Recommendation Report for Planning Permission for Works or Extension to a Dwelling

REF NO: BR/123/21/HH

LOCATION: 112 Victoria Drive
Bognor Regis
PO21 2EJ

PROPOSAL: Erection of side and rear extension following demolition of existing conservatory.

Proposed West Elevation

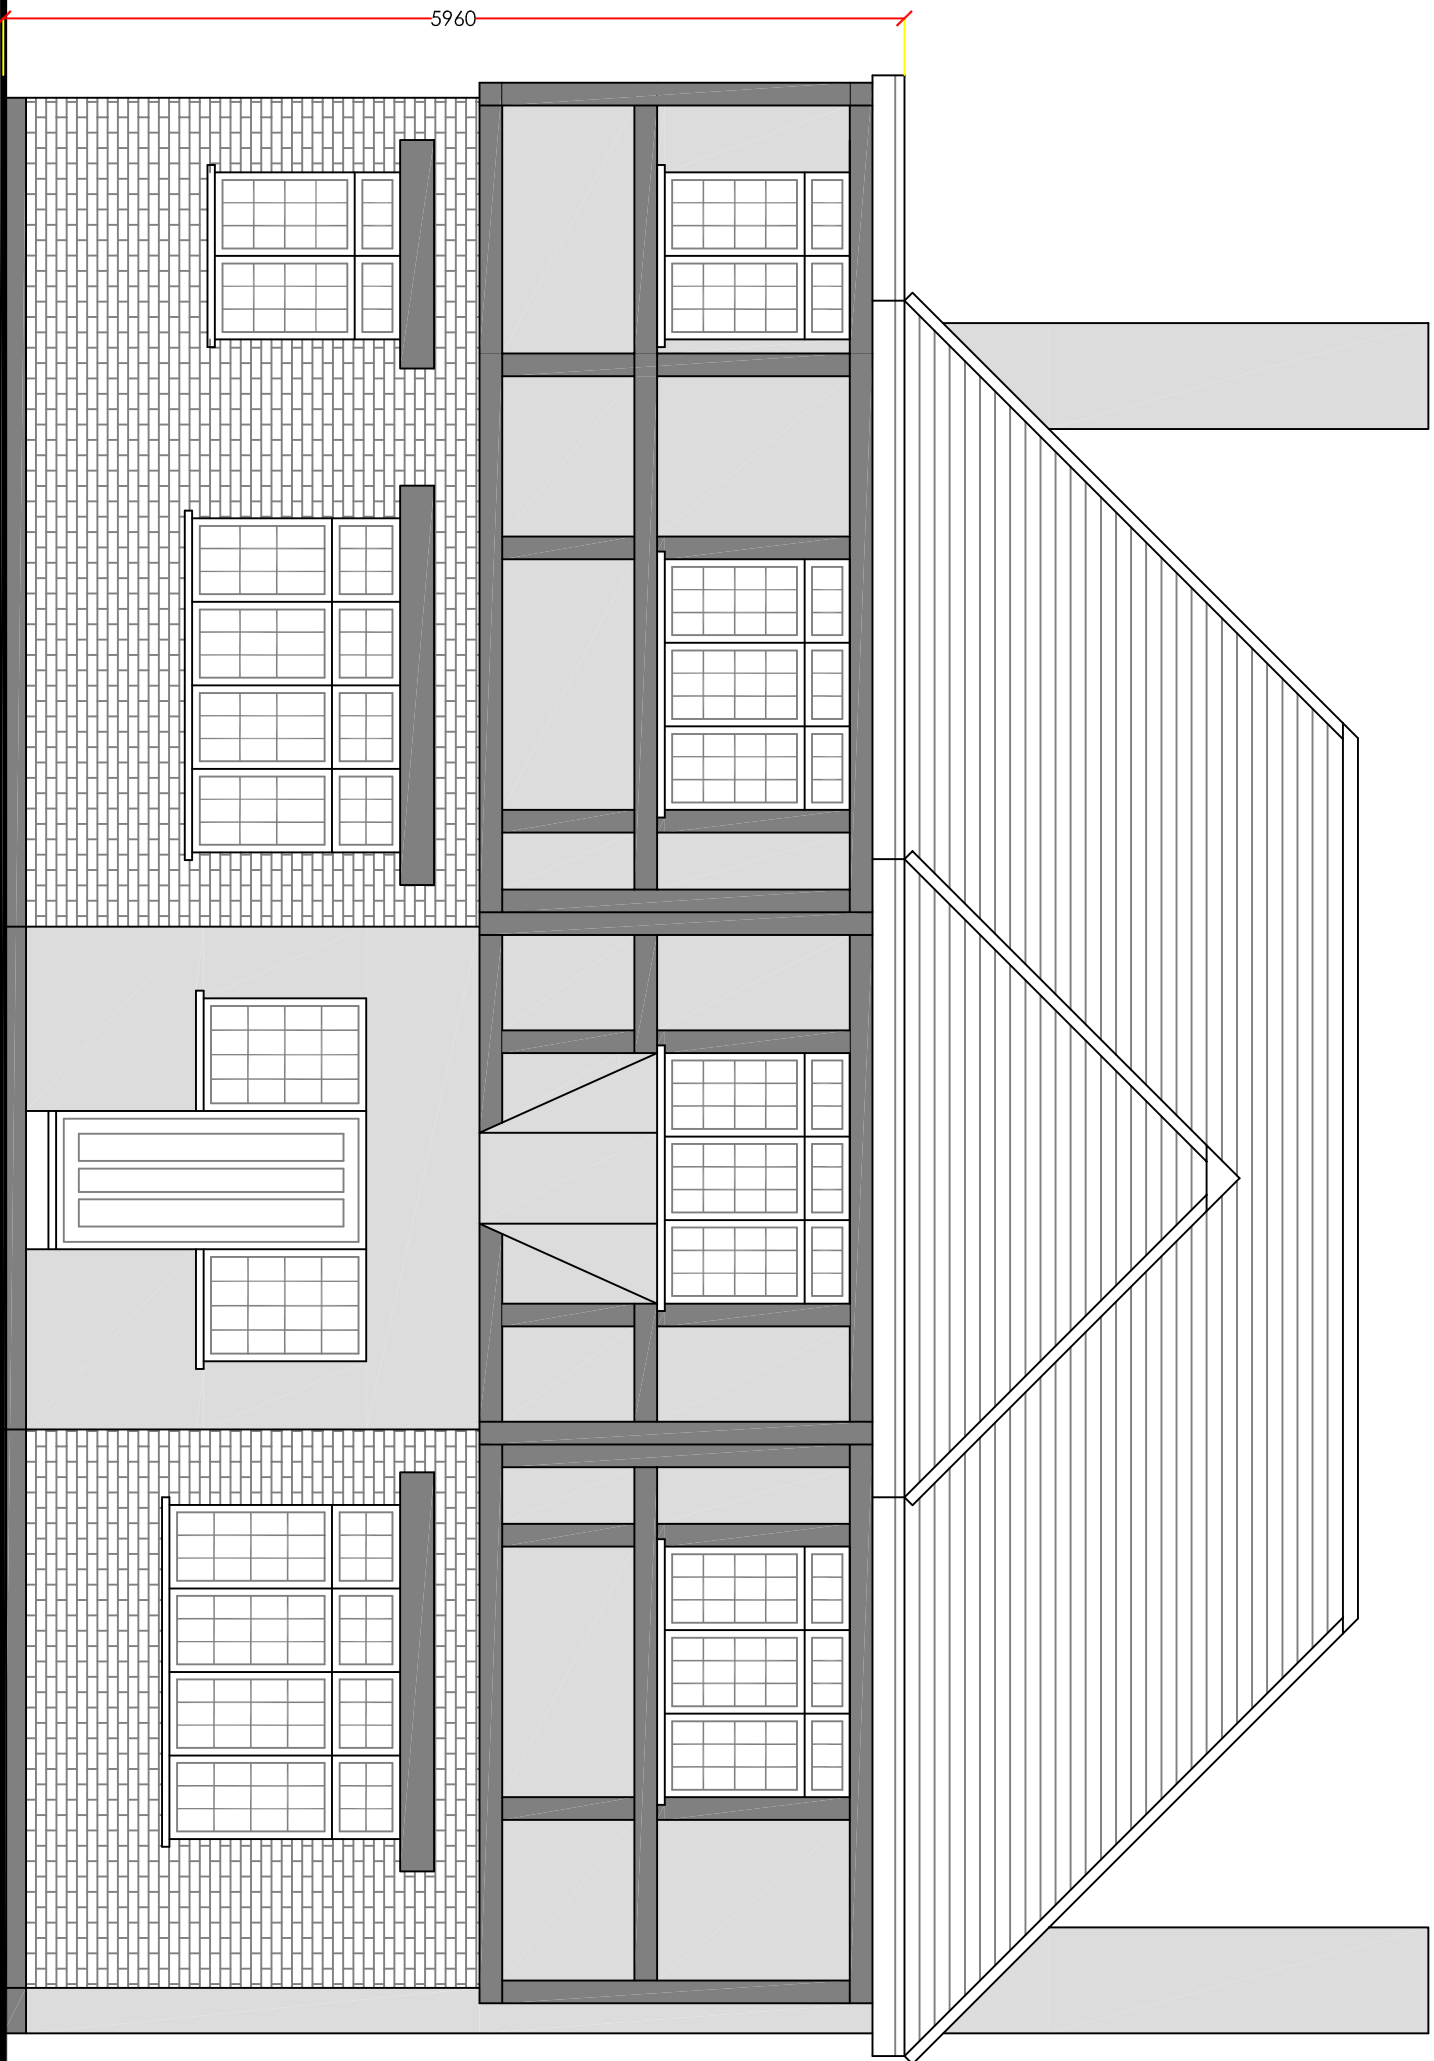
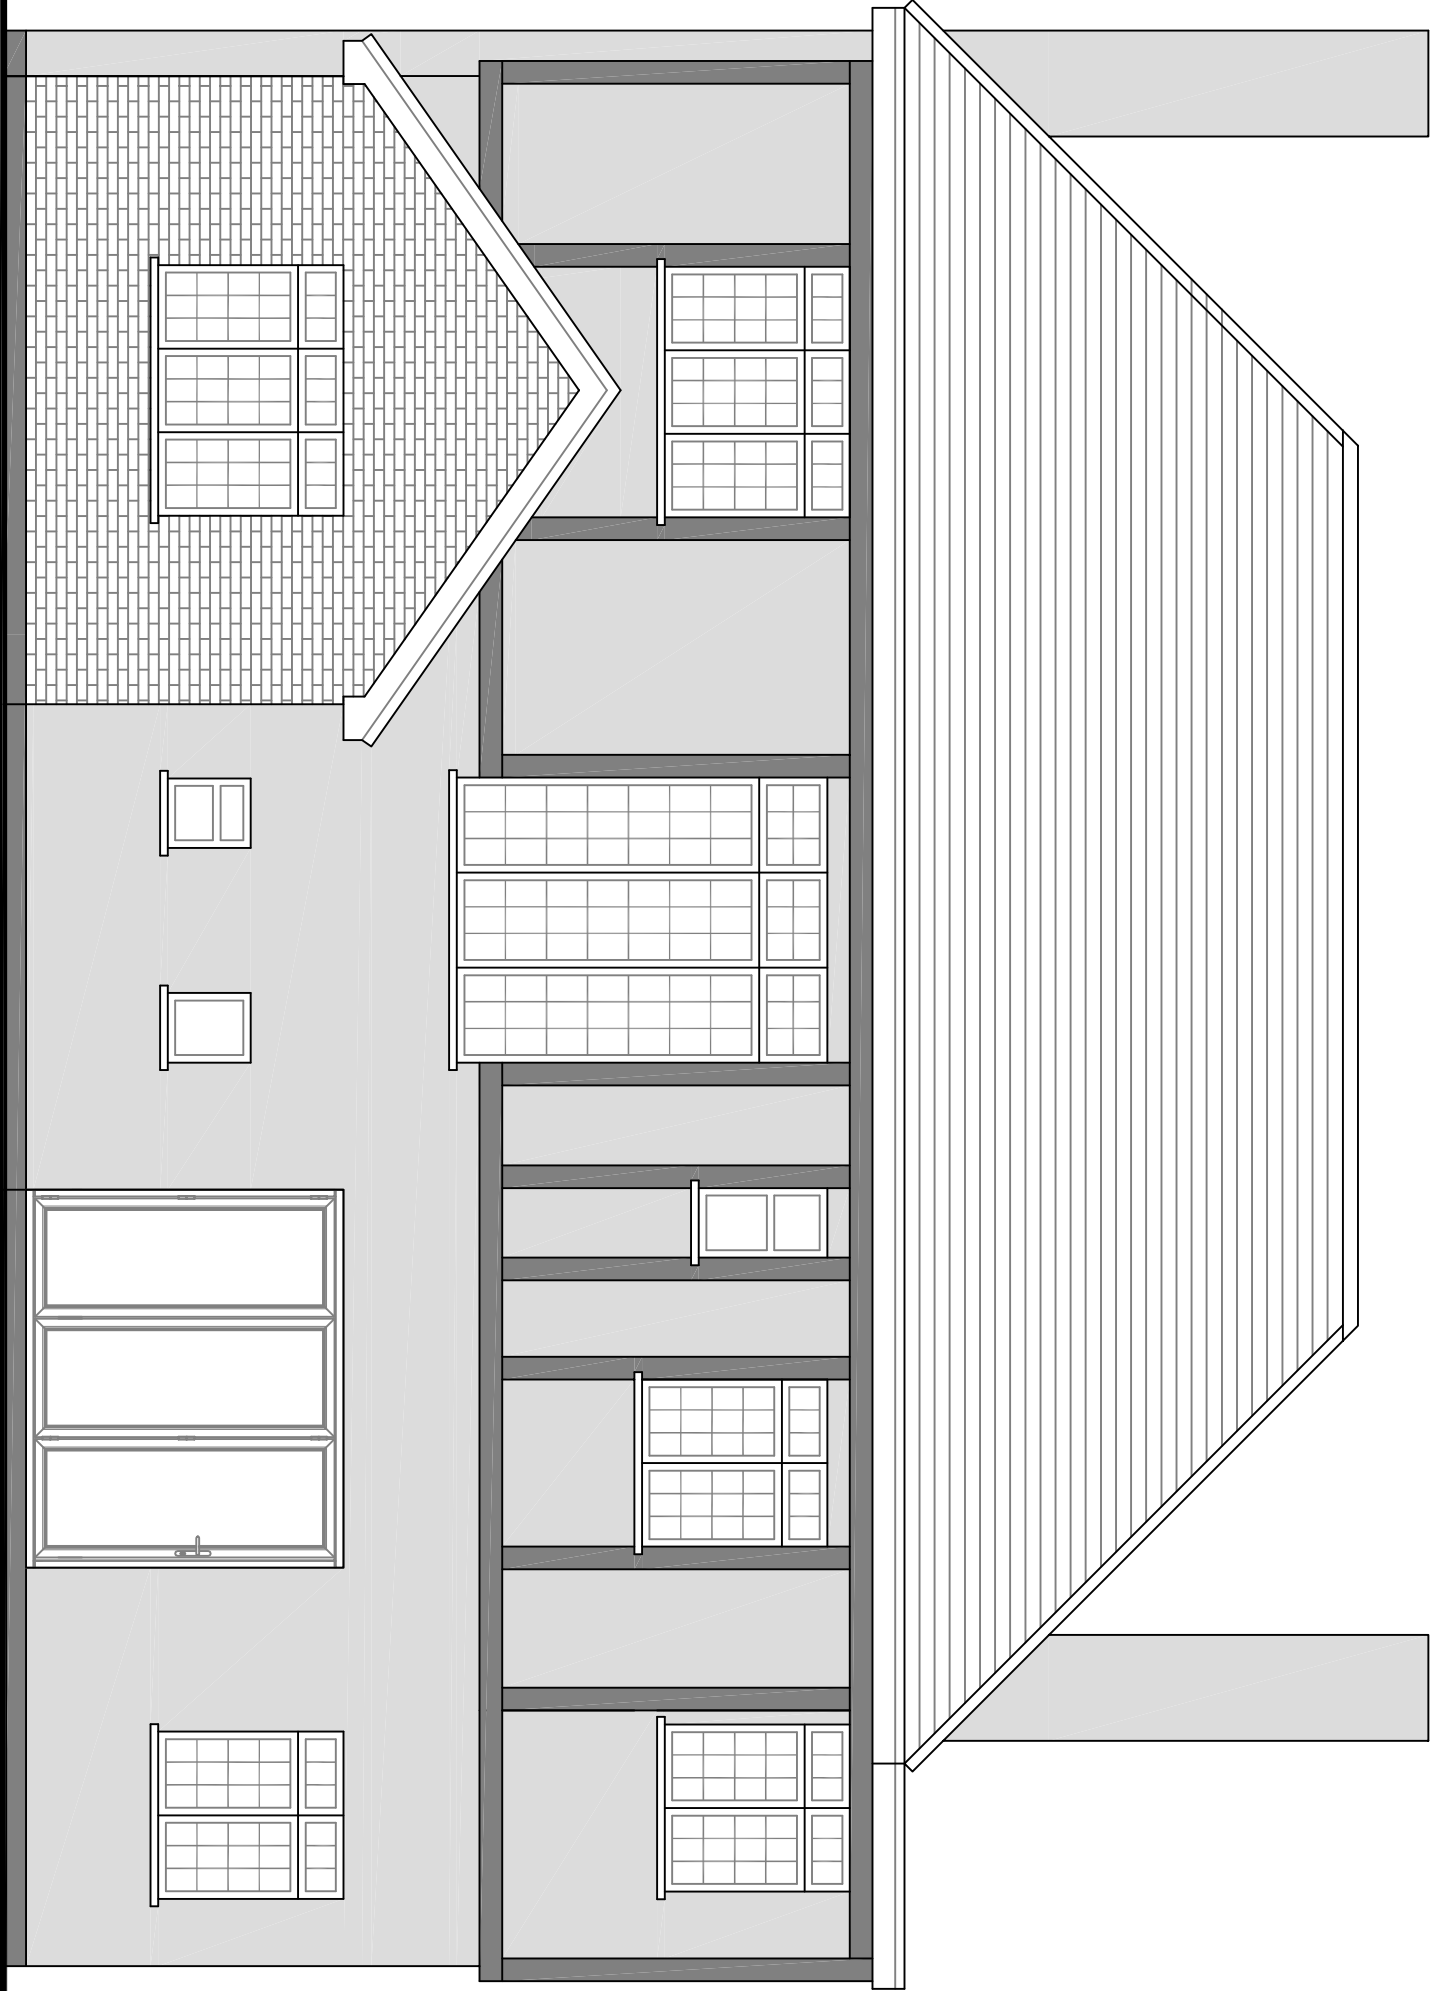
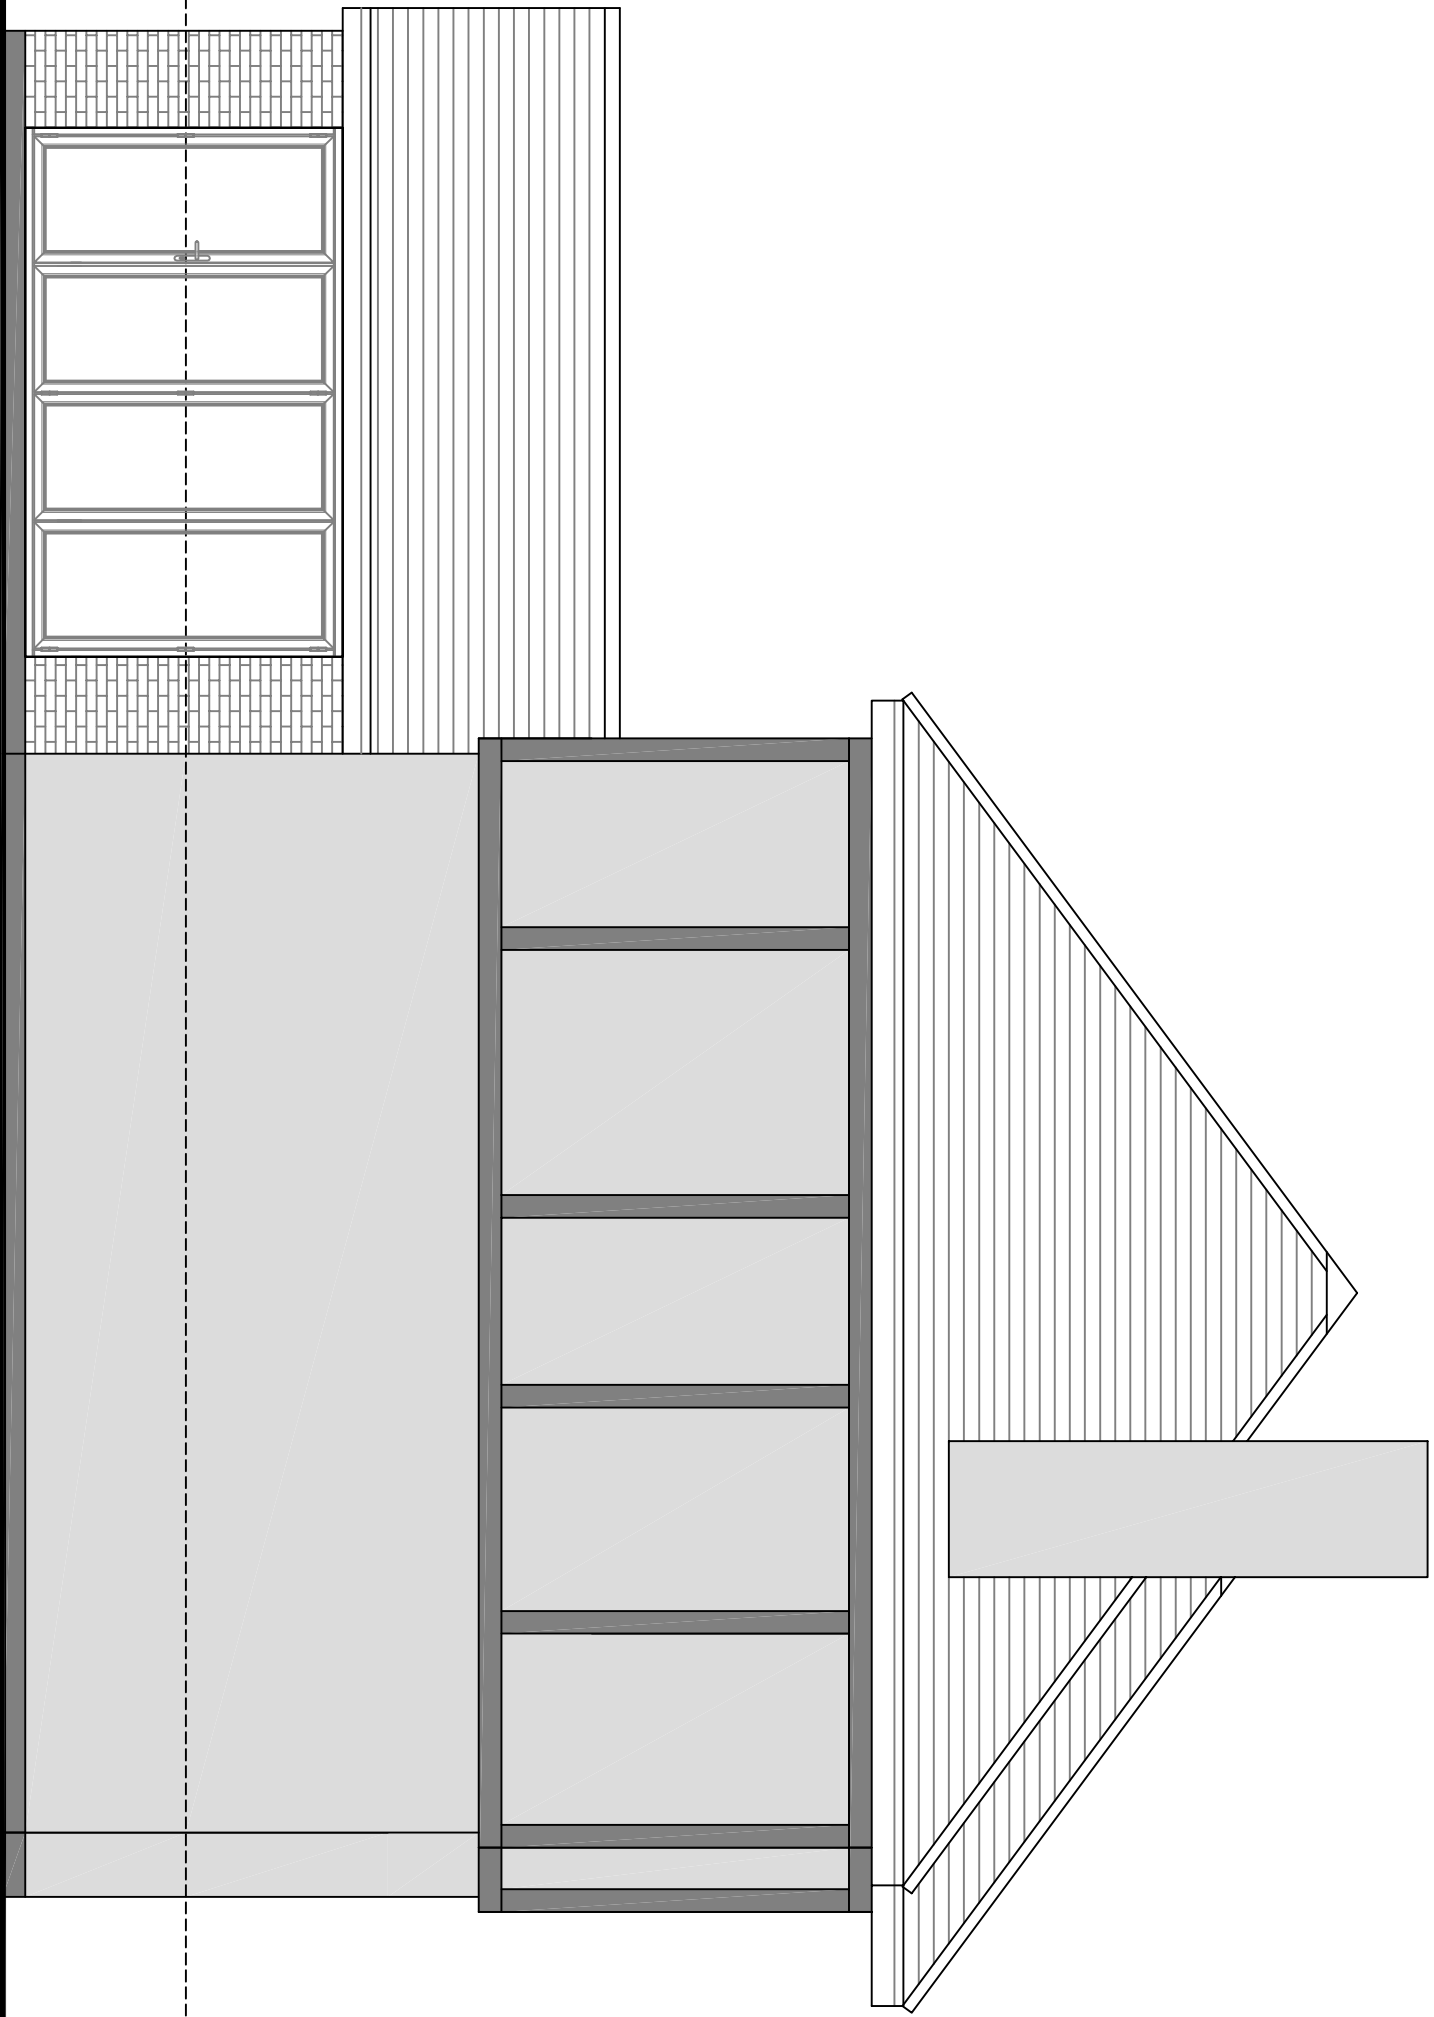
The side extensions measures 1.12m wide, 7m deep and 6m high approx.

The single storey rear extension measures 4.09m max level, 2.22m eaves level, 4.74m depth and 4.14m wide approx.

The proposed side extension would be built in flush with the main dwelling and roof profile would be integrated within the existing roof profile. The fenestration pattern would also match the host dwelling. The extension has limited width and does not extend across the width of the plot and over 1m distance from the boundary is maintained. Overall the extension would blend in within the architectural composition of the main house and appears to subordinate to the main house.

Class M of the design guide encourages the side extension to be set back from the main house and also gap should be maintained from the boundary to avoid any terracing effect. In this case extension is broadly aligned with the design guide, due to the detached nature of plot the extension would not cause terracing effect. The single storey rear extension in terms of design and scale is considered to be in keeping with the character of the host dwelling. As mentioned in the design guide the single storey extensions have lessor impact on the street scene, in this case the rear extension would not be visible from the public domain.

The single storey rear extension measures approximately 4.74m in depth and this contradicts with design guide class M. The existing extension on the boundary approximately measures 3.80m; therefore additional increase by 95cm in not going to significantly alter the existing situation. Also due to the detached nature of the plot, the proposed rear extension is not going to have significant impact in terms of overbearing, loss of outlook or loss of light. The two storey side extension does not extend across the full width of the plot, hence the distance is maintained from boundary; therefore the extension does not appear to have any detrimental impact on the adjoining property. The fenestration pattern does not cause any overlooking into the habitable areas of the adjoining dwelling.
